SHEPHERDS BAY URBAN RENEWAL, MEADOWBANK

STAGE 1 PROJECT APPLICATION (MP 09_0219)

Response to Additional Information Request Preferred Project Report

RESPONSES TO ADDITIONAL INFORMATION REQUEST

Building Name : STAGE 1 PROJECT APPLICATION (MP 09_0219)
Drawing Title : UPPER BASEMENT PLAN

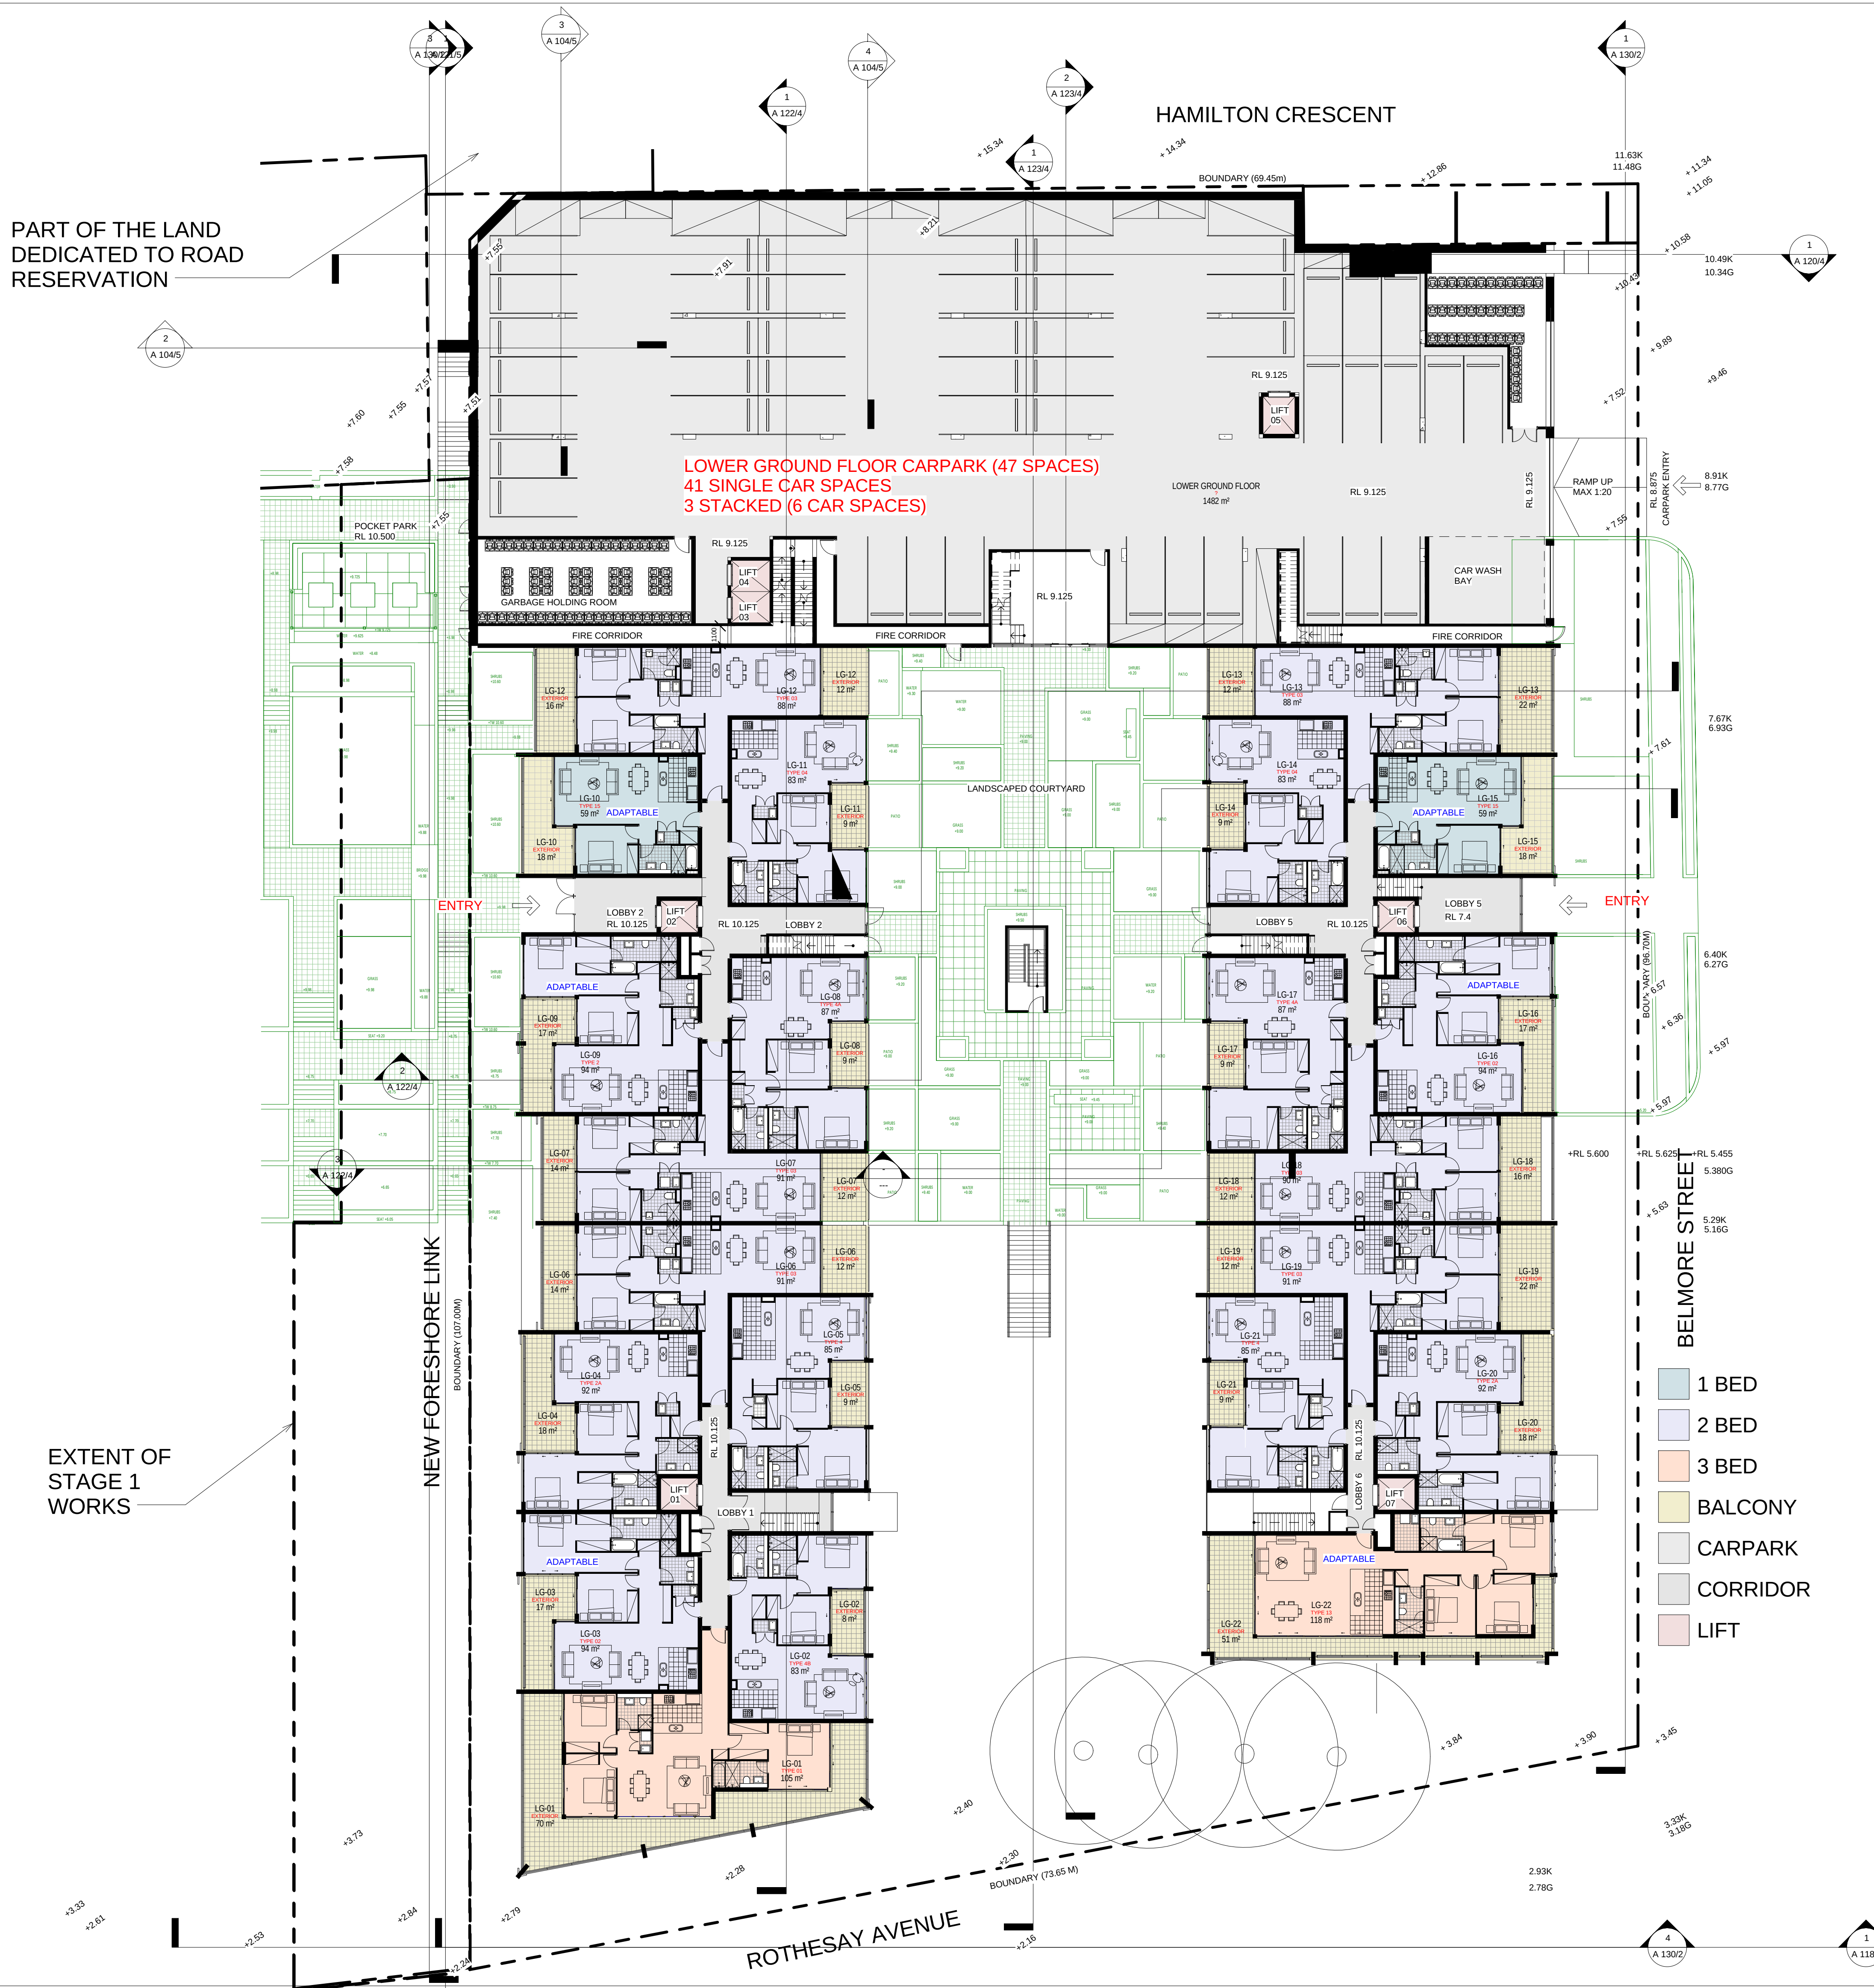
8.	Allocation of visitor parking spaces within the basement car park to be provided.	Allocation of visitor parking spaces within the basement car park has now been indicated on the relevant basement plan.	See Architectural Drawings - A 102-6 at Annexure 1

10.	Details of loading areas, car wash bays etc within the basement.	Car wash bays nominated in the plan. Because of the multiple lift cores no dedicated loading areas with increased head height over 2.2m - 2.3m are provided in the basement.	See Architectural Drawings - A 102-6 at Annexure 1

Drawing Title : ROTHESAY AVENUE ELEVATION

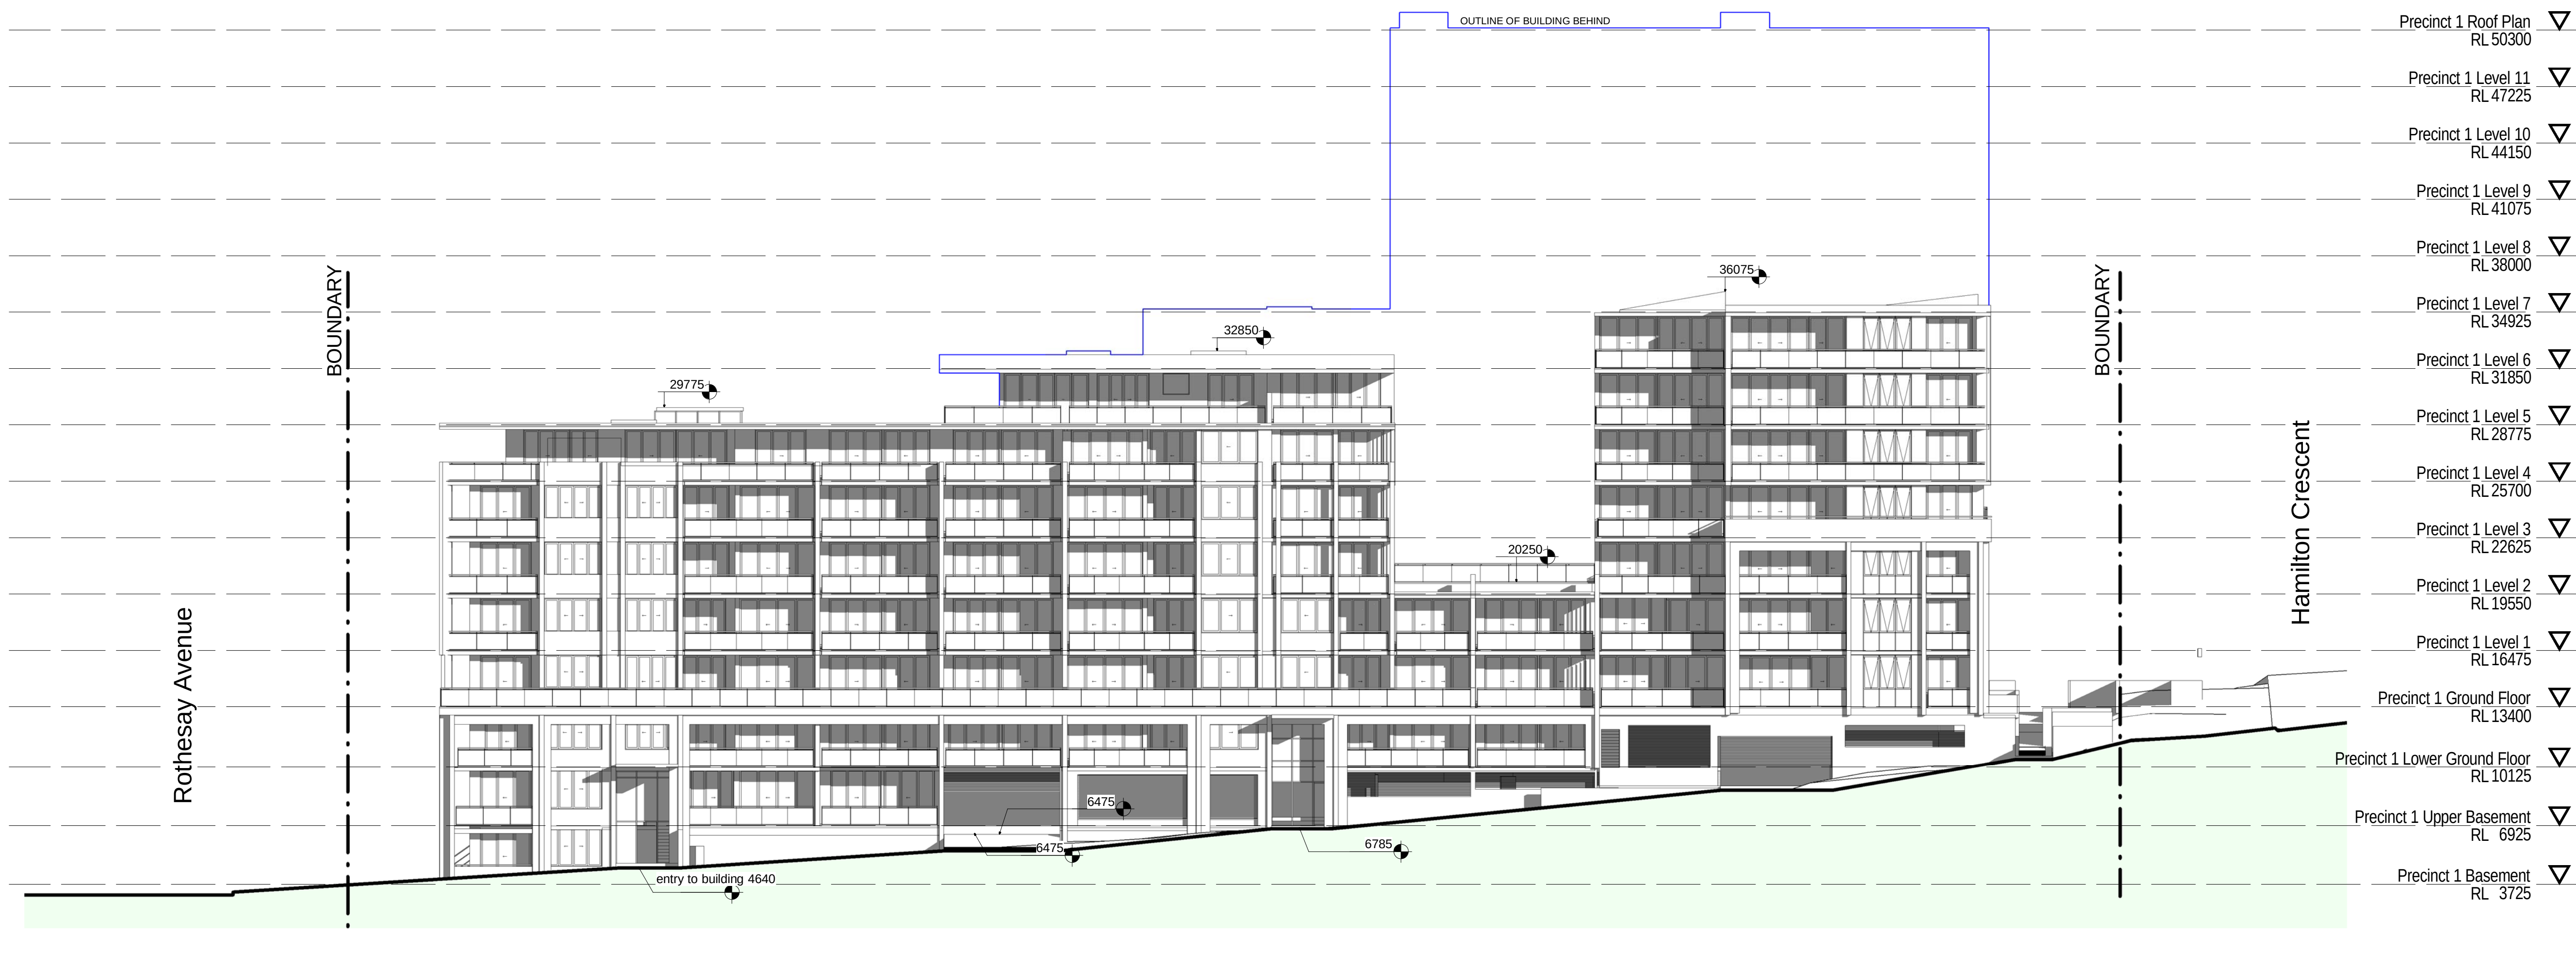
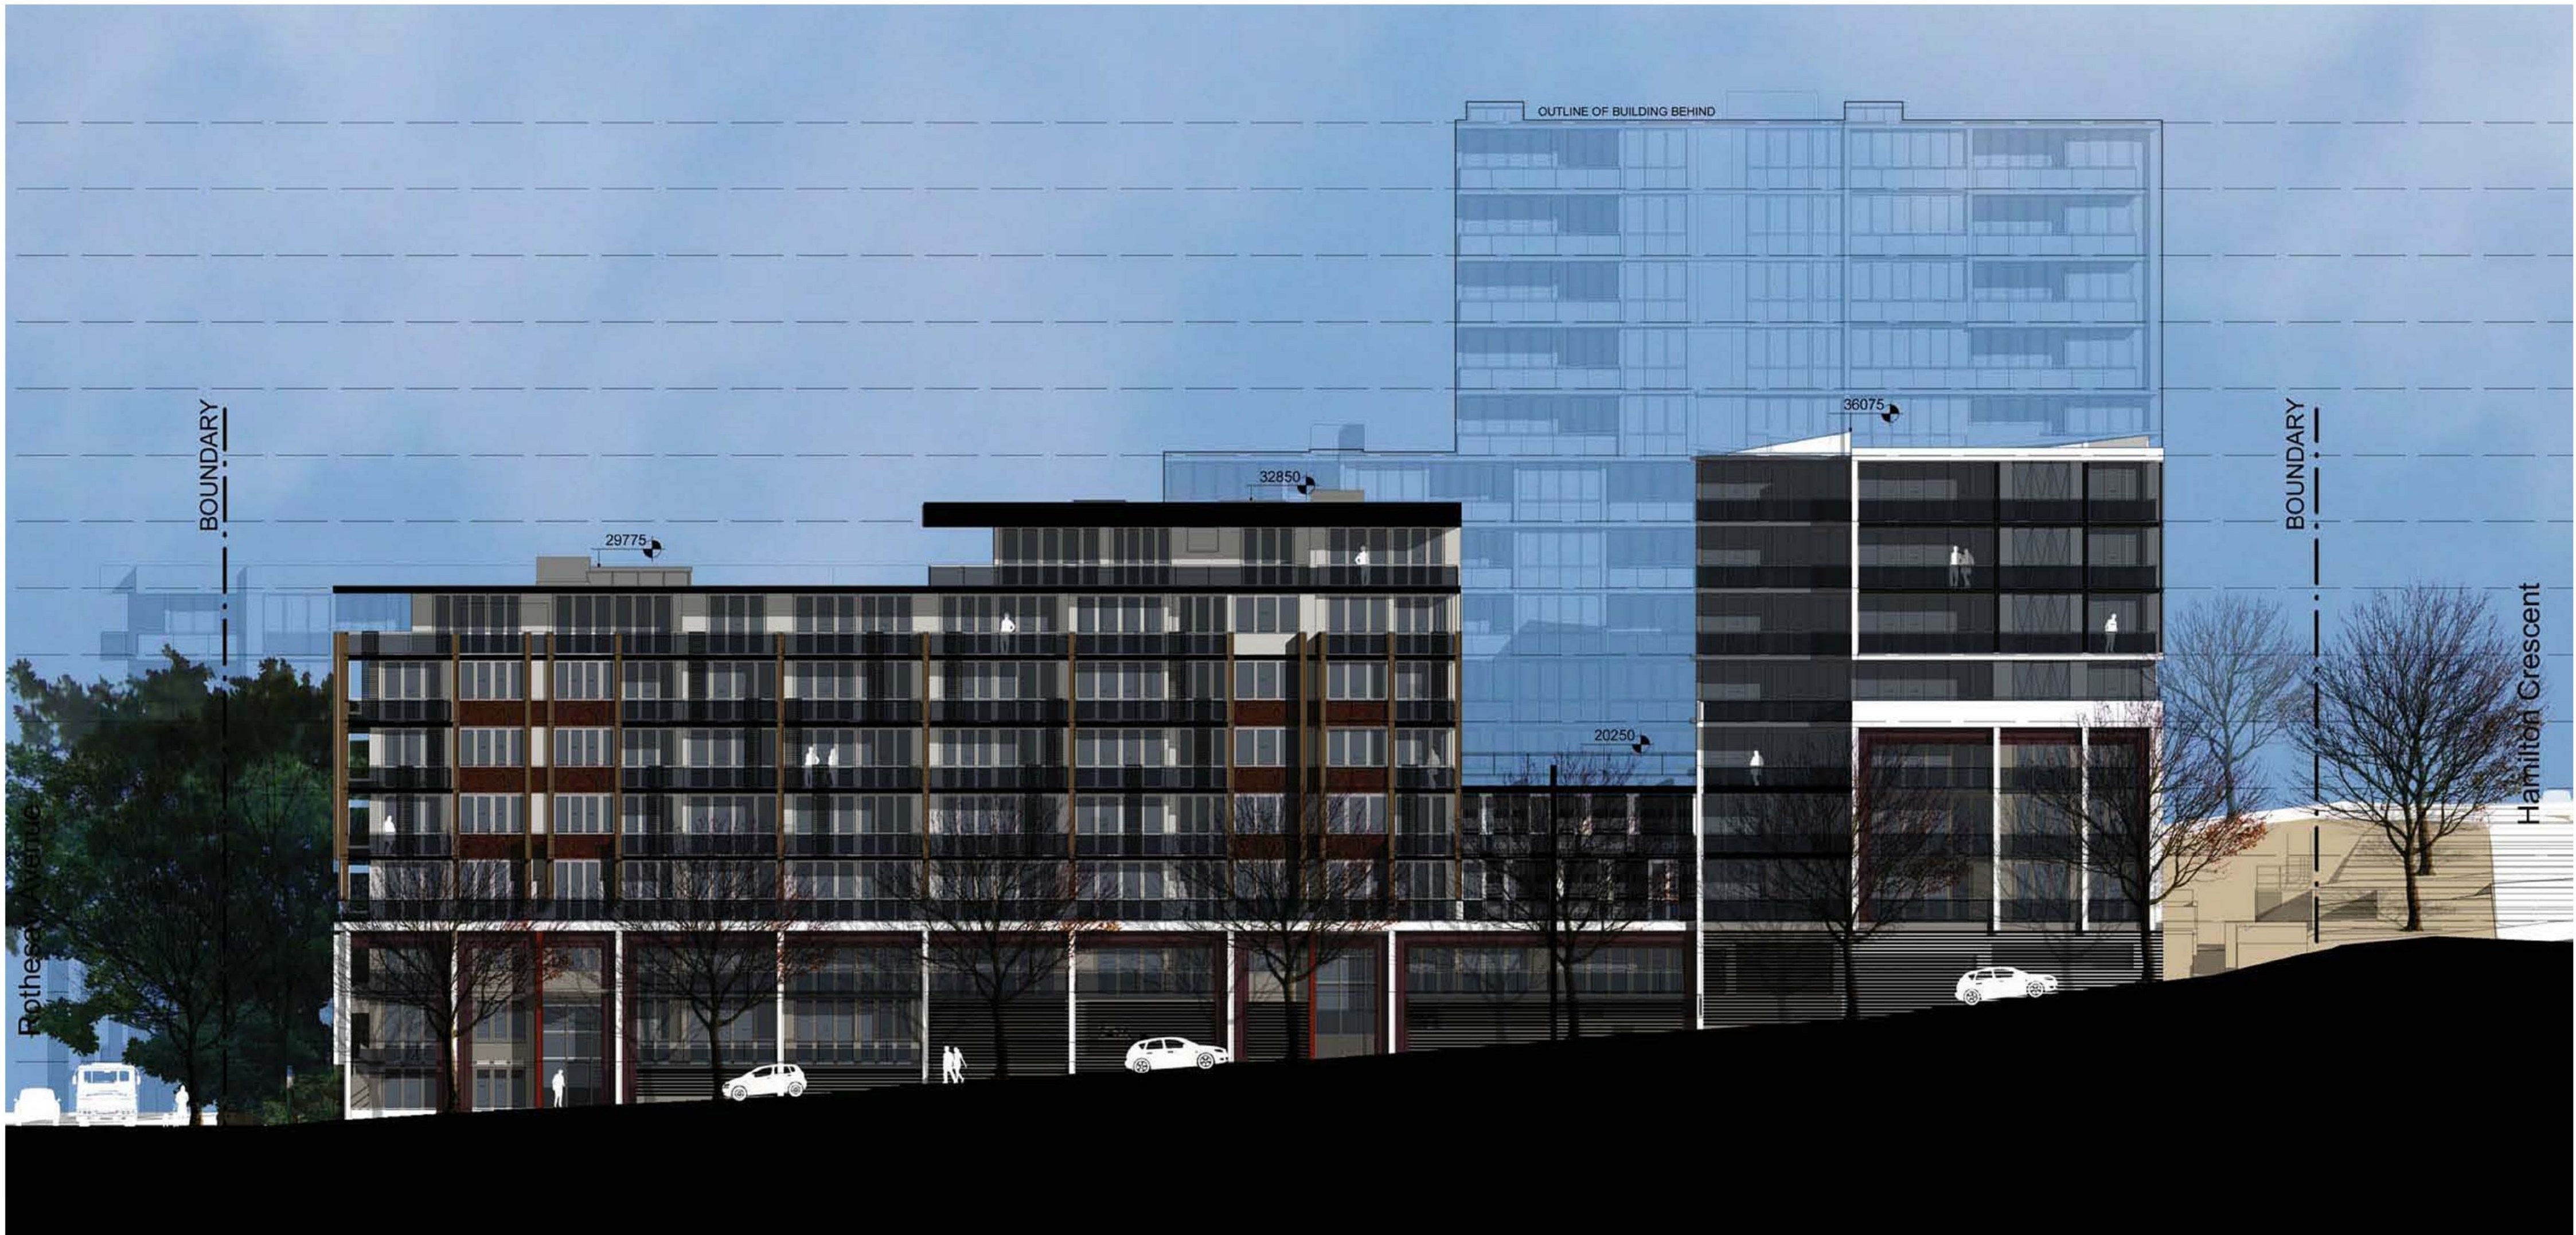
16.	Confirmation that fencing and security gates are provided to the communal open space at the Rothesay Street frontage, and if so the materials/height of the fencing.	It is confirmed that the central communal space is to be fenced with security gate with swipe card access entry. Fencing details have now been included on relevant plans and elevations.	See Architectural Drawings - A 101-7, A 118-4 at Annexure 1
